Application WA/73/17/OUT

Response to comments from West Sussex County Council (highways) and Highways England

Written by : Gary Heard (Peter Brett Associates LLP)

28th November 2017

Drawing Issue Status					
INDICATIVE - FOR INFORMATION					
LAND EAST OF WANDLEYS LANE A27 / A29 WEST ROUNDABOUT JUNCTION GEOMETRY					
Client					
WELBECK STRATEGIC LAND II LLP					
Date of 1st Issue 29.09.17		Designed JHJ	Drawn MJB		
A3 Scale 1:500		Checked GH	Approved GH

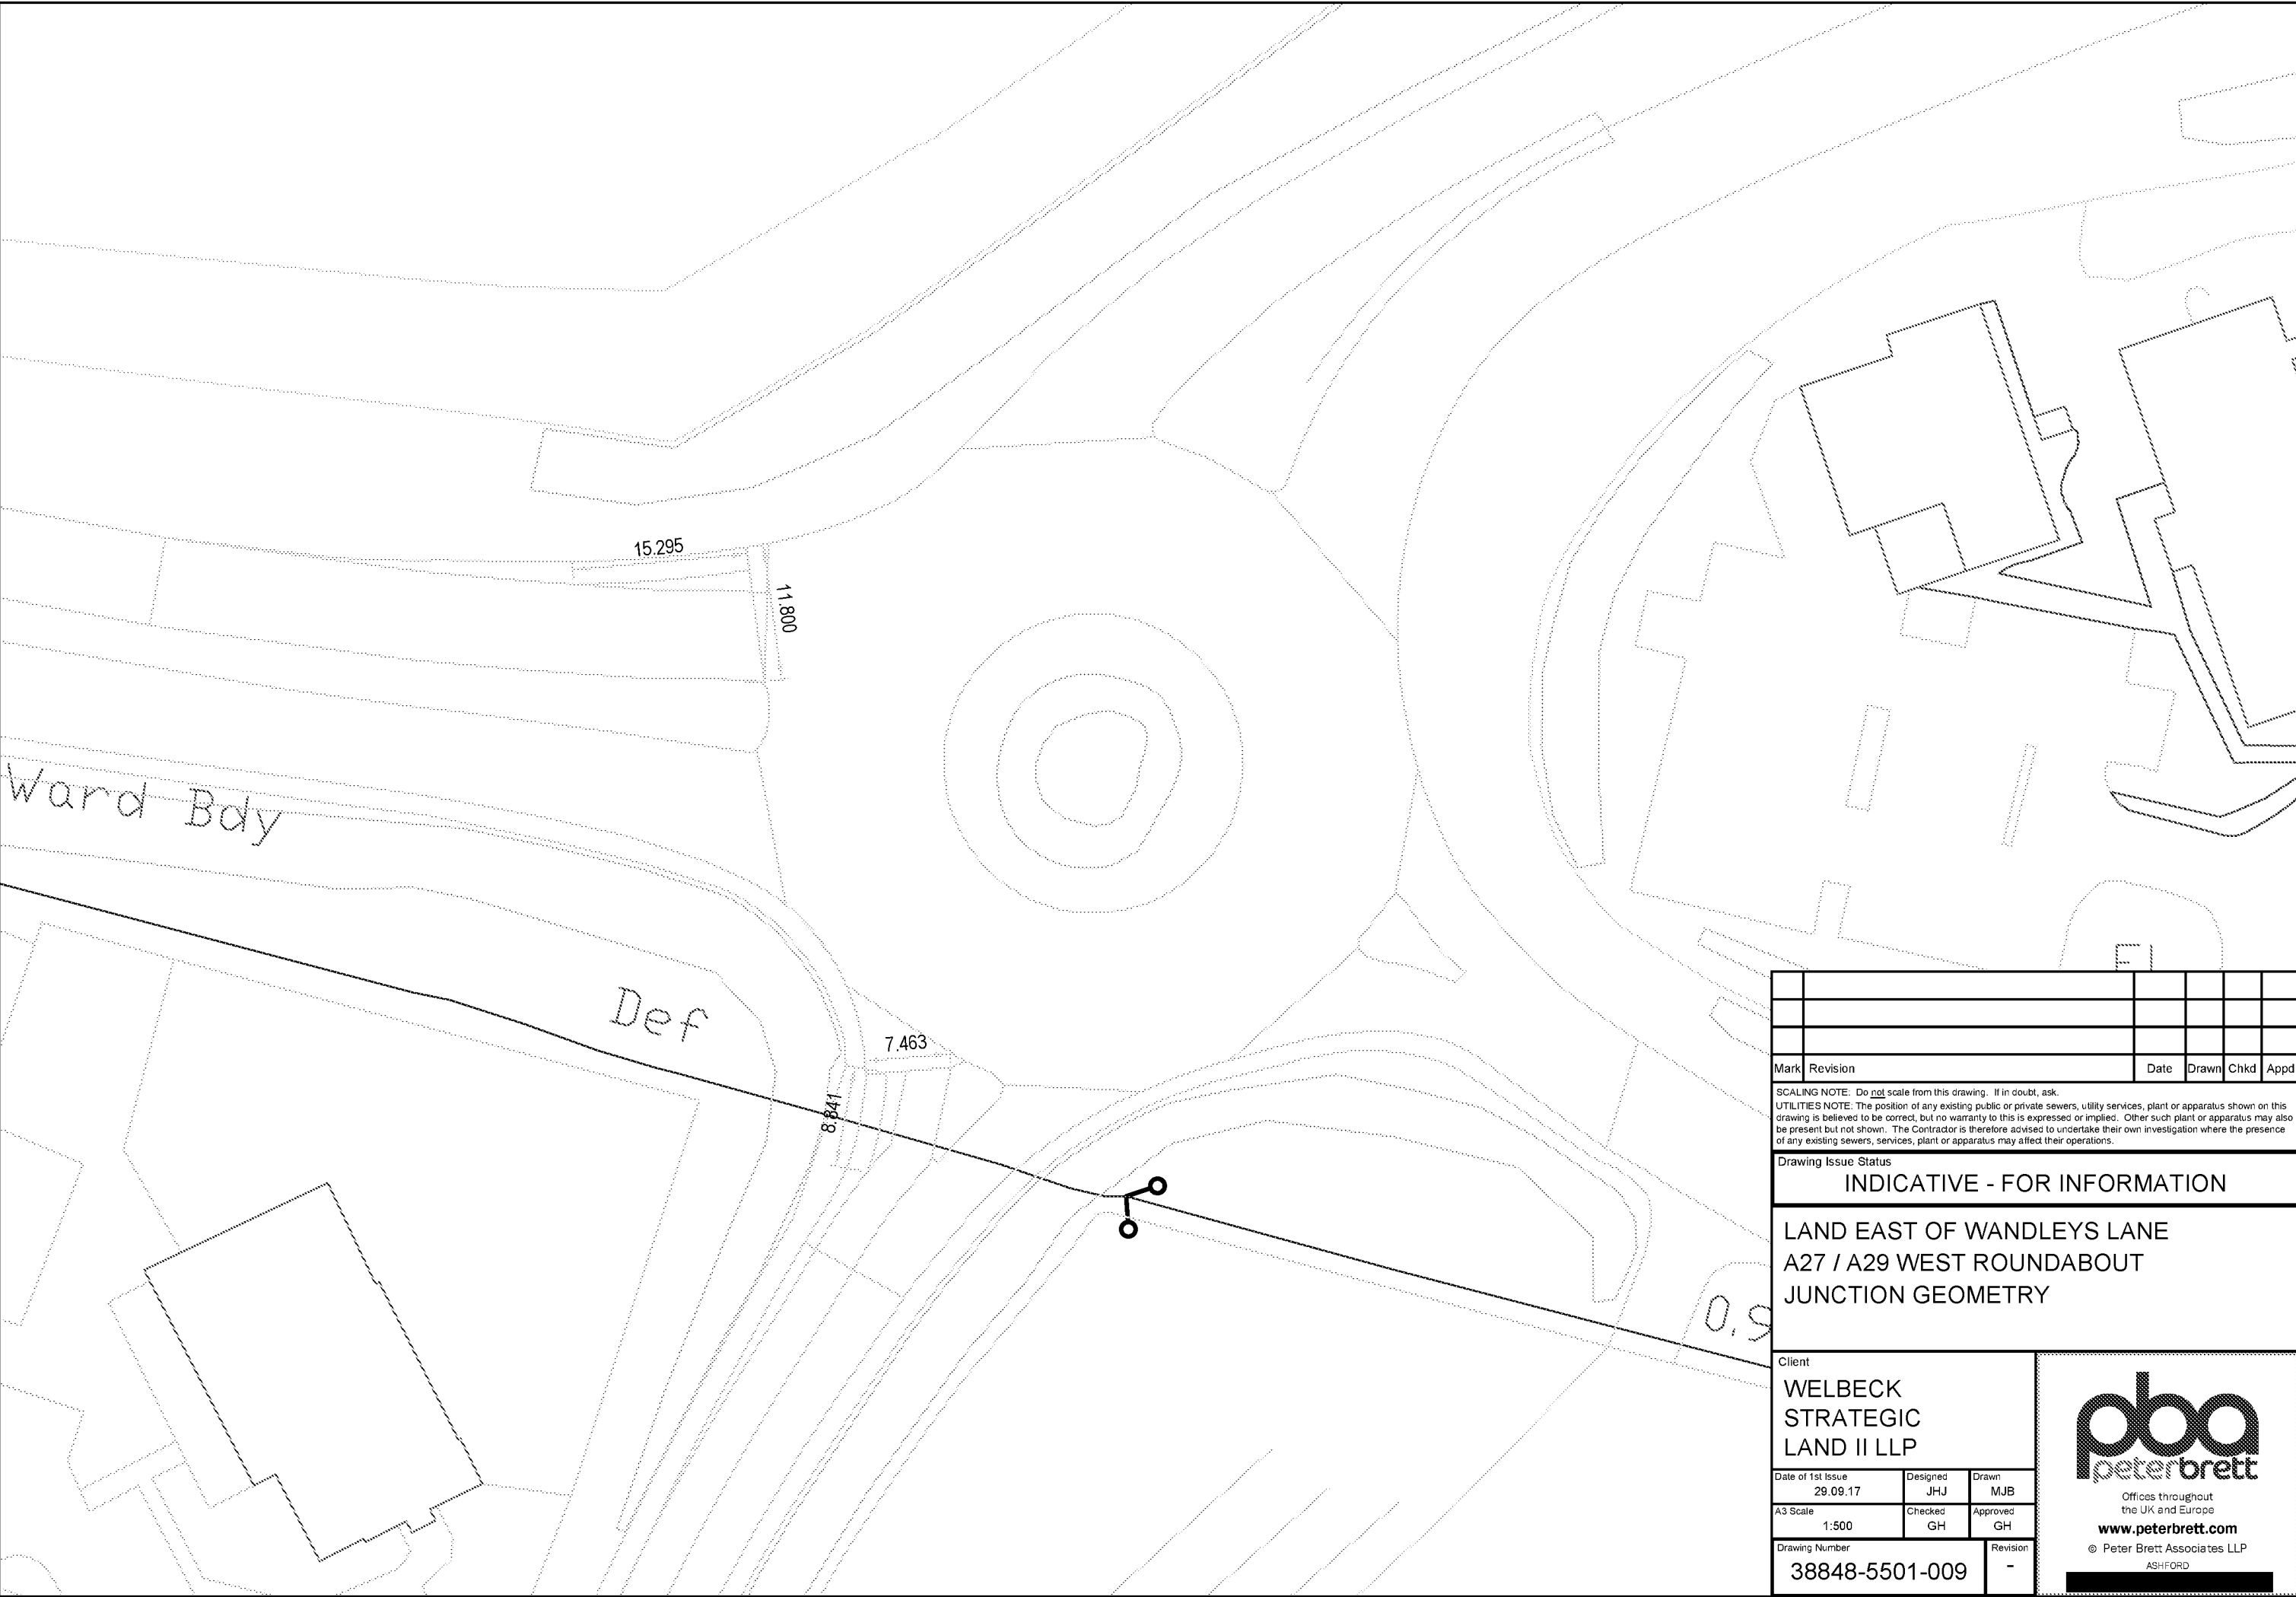
- Paragraph 8.6.3 states that the proposed A27 / A29 West roundabout mitigation is contained in Appendix M, but there does not appear to be such a plan and thus clarification is sought on this.

- PBA requested the latest Linsig model (developed by Systra) for this junction. The most up to date Linsig model was supplied to PBA by WSCC including the mitigation scheme. This is included at Appendix N rather than Appendix M as stated at 8.6.3.
